**KIRKLEES METROPOLITAN COUNCIL
INVESTMENT & REGENERATION SERVICE**

DELEGATED DECISION TO DETERMINE PLANNING APPLICATIONS

Reference No:	2025/62/91940/E
Site Address:	69, Chapel Lane, Heckmondwike, WF16 9JR
Description:	Erection of two storey side extension and single storey front and rear extensions with balcony above, dropped kerb and associated alterations
Recommending Officer:	Elenya Jackson

DECISION – Refused

Proposed Side Elevation (South)

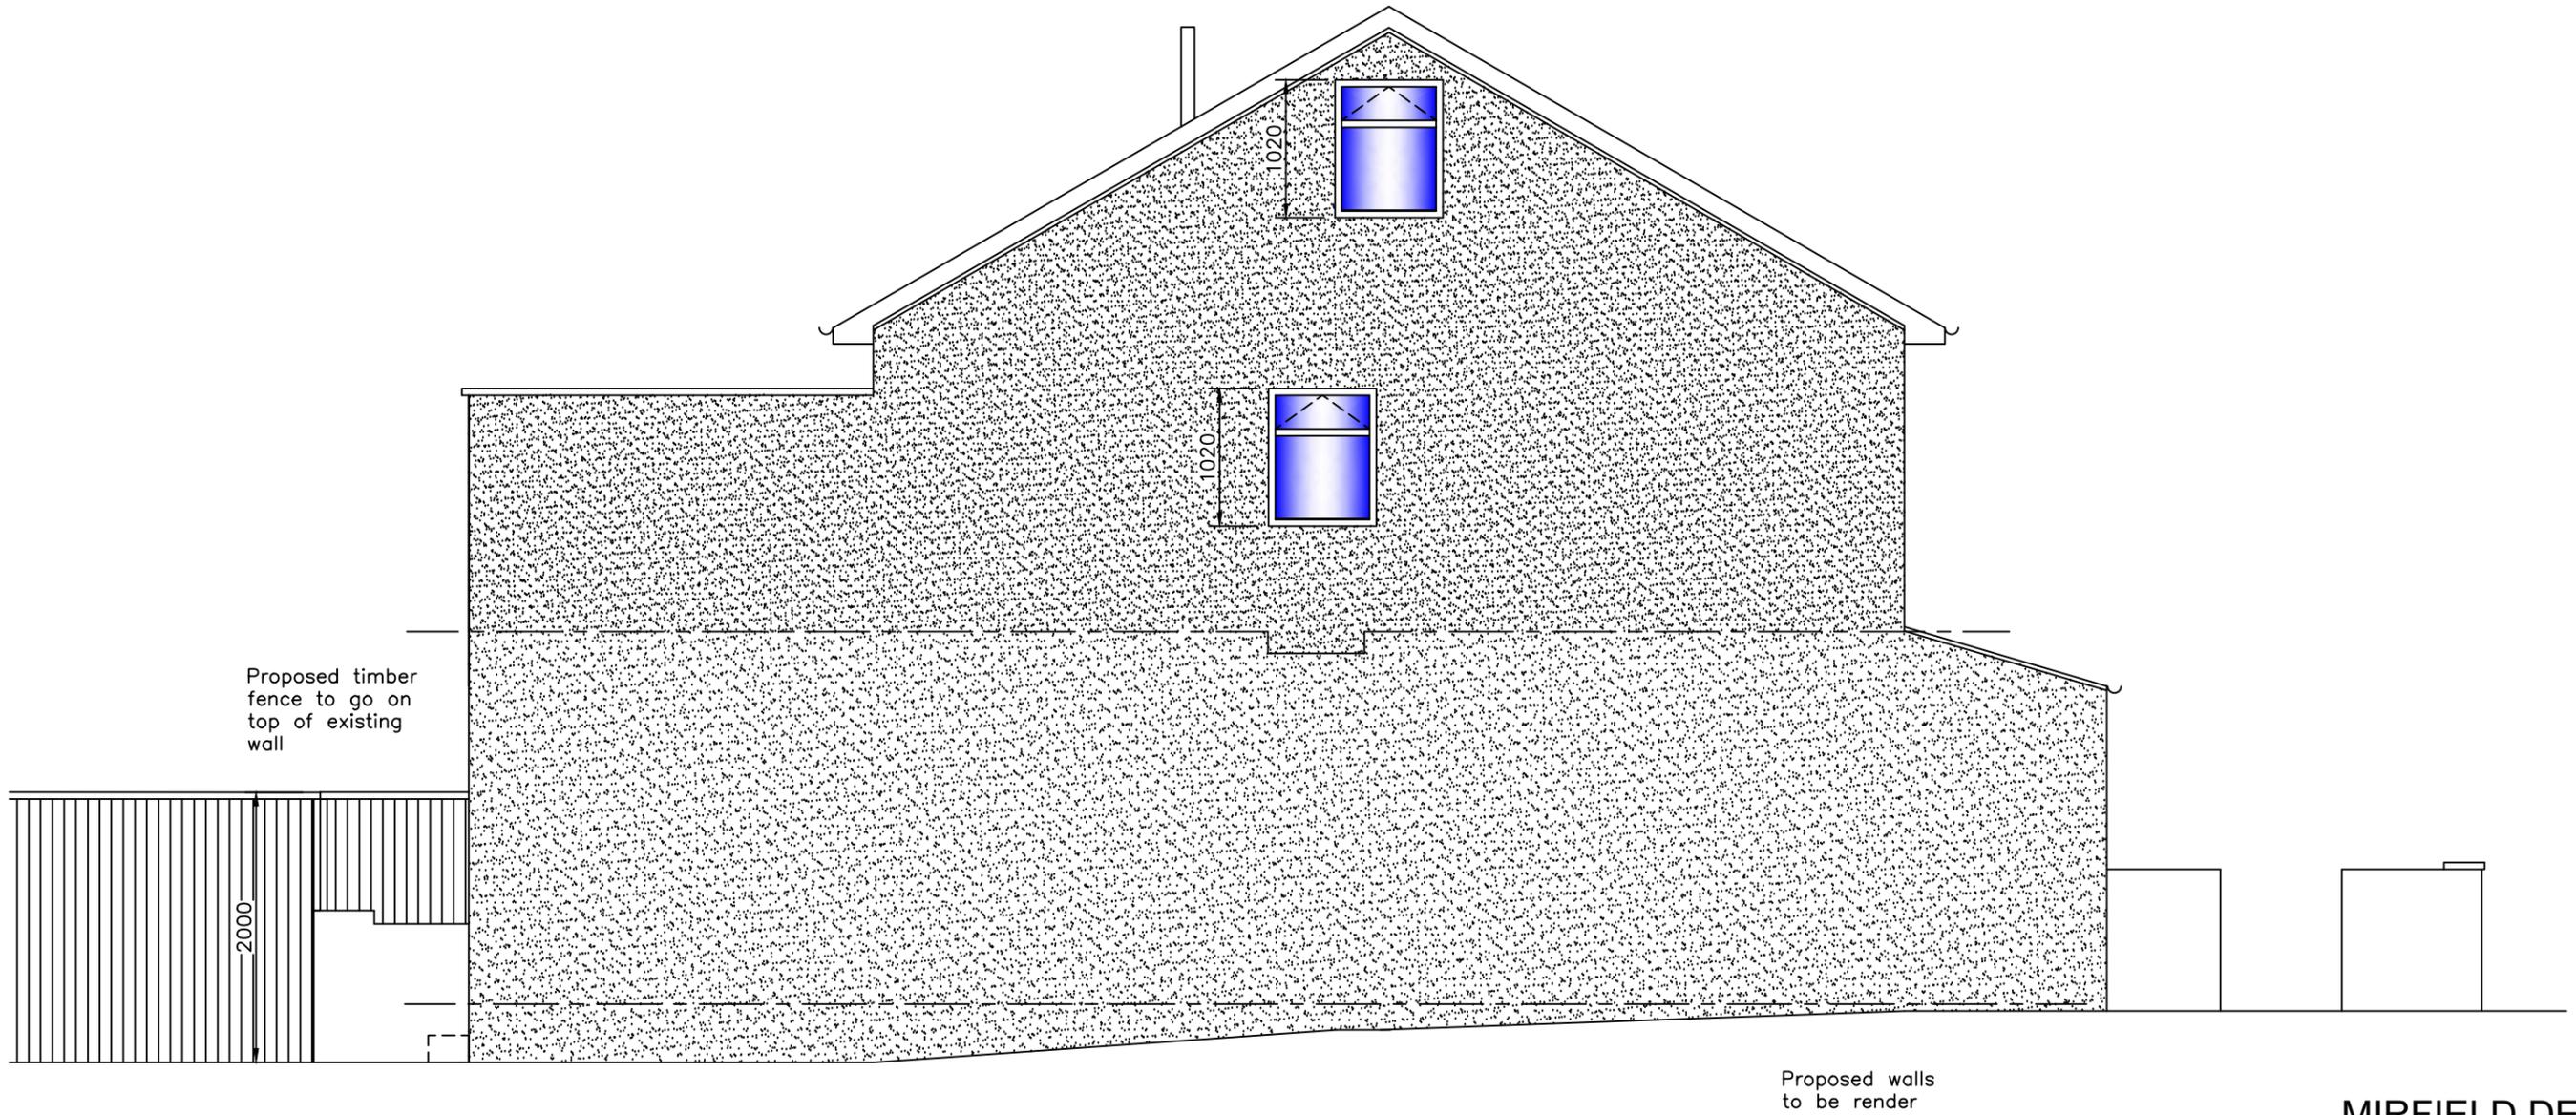
The two storey side extension would not be set back or set down from the host dwelling which would reduce the proposals subservience to the host dwelling and would unbalance a semi-detached pair when viewing the property from Chapel lane. In addition, the extension would significantly project beyond the established build line along Green Lane.

It is considered that, due to the currently uninterrupted build-line within Green lane, the existing dwelling being situated within a highly prominent position within the street scene when coupled with the limited size of the plot when considering the scale of proposed development on site, the two storey side extension would be read within the public realm as an obvious and obtrusive addition within the street scene which would fail to integrate with the host dwelling and would not assimilate well in the character of the area contrary to the House Extensions and Alterations SPD and Policy LP24 of the Local Plan.

The proposal includes the alteration of the roof design from a hip to a gable end. It is considered that there are few examples of gable ends within the street scene and wider area and its introduction would further increase the prominence of the extensions within the street scene, would further unbalance a semi-detached pair and would be out of keeping with the prevailing character of the area.

Proposed Site Plan

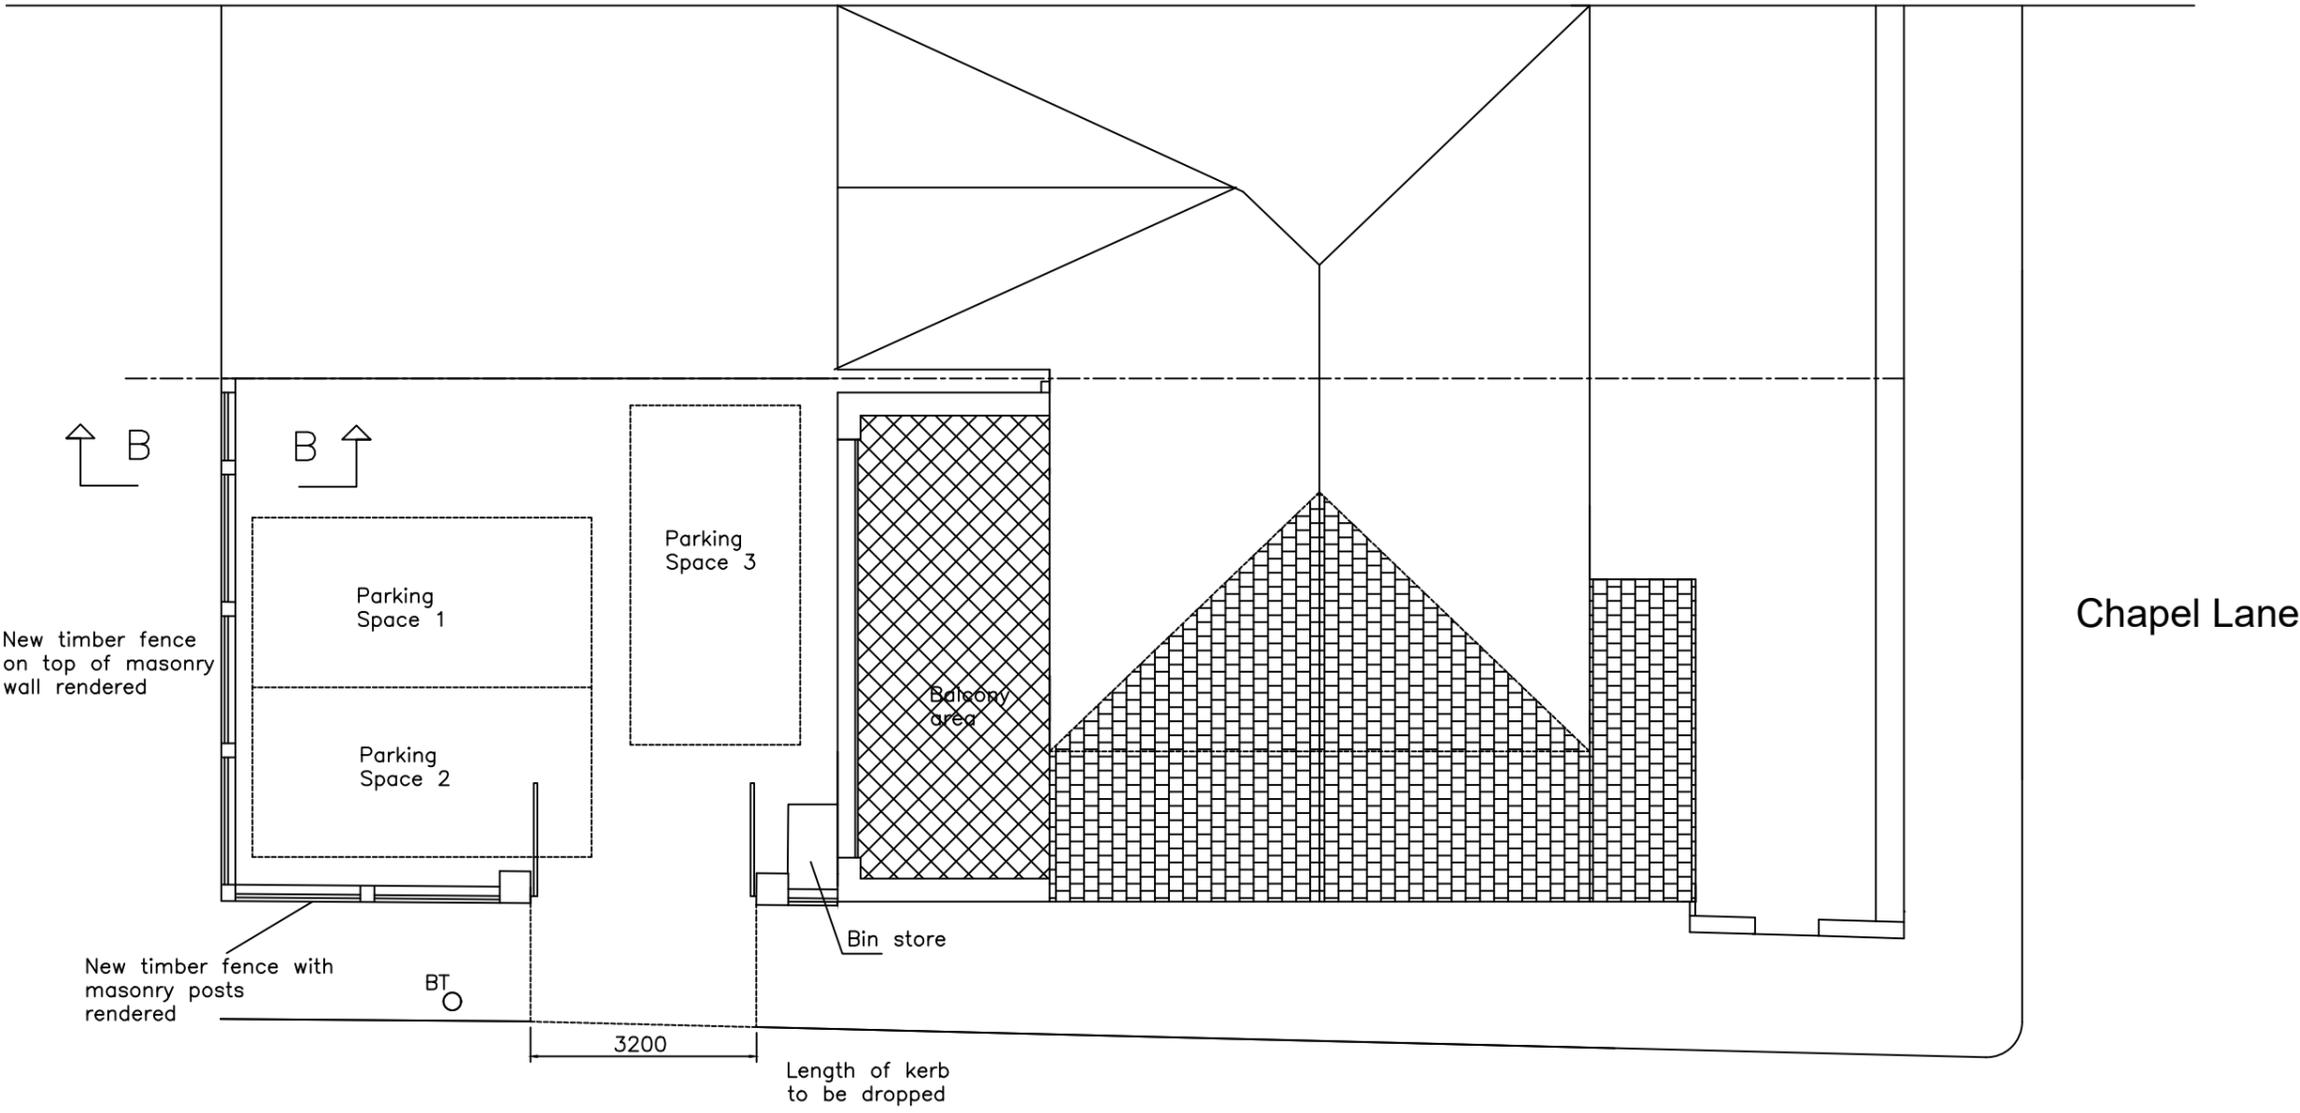
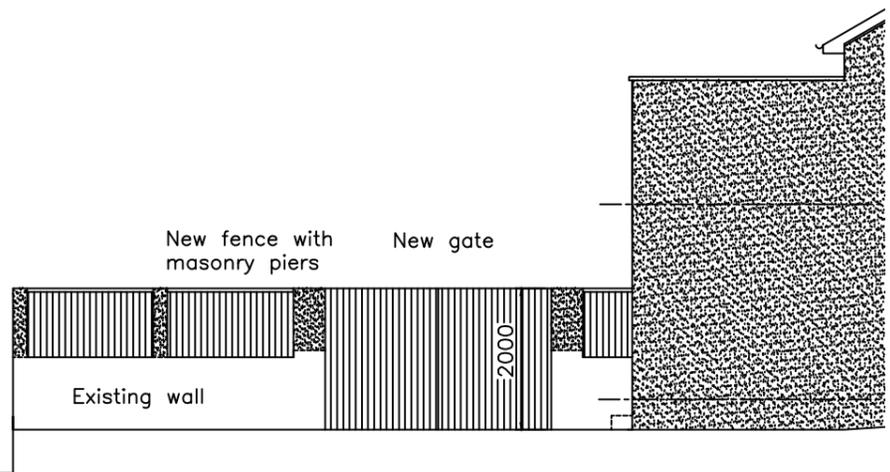
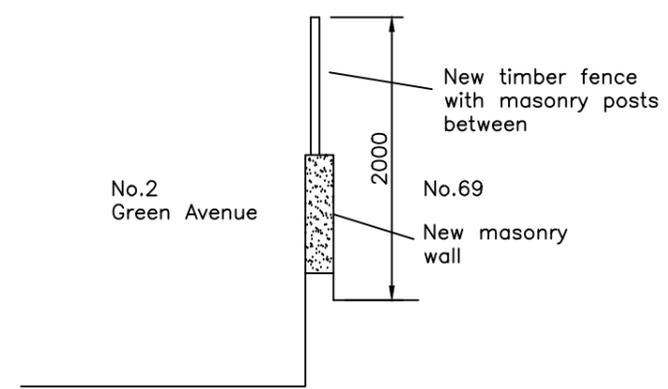
The proposal would also include alterations to the existing boundary treatment on site to increase the fencing to 2m. The proposed fence would immediately abut the pavement and be set forward of the build line within the vicinity. This would interrupt openness and sight lines in looking in an easterly and westerly direction and be out of keeping with the prevailing character of the street scene.

Furthermore, the proposed fence by virtue of its siting, scale and design would result in an incongruous feature within a prominent location which would detract from the character and appearance of the host property and the wider street scene.

The proposal would increase the height of the boundary treatment to 2m in height immediately adjacent to the highway which would obstruct visibility splays. The proposed entrance gates would not be set a sufficient distance into the plot which would result in a vehicle having to wait in the highway for the gates to open, the proposal would impact pedestrian intervisibility and adversely impacting on highway safety. In addition, the location of the car parking spaces does not appear to be accessible as the proposed gate would intercept parking space 2.

Officers consider that the proposal would require, swept path analysis and a demonstration of visibility splays which have not been provided to support the application. In addition, the dropped kerb would require a separate section 184 license from the Highways Authority.
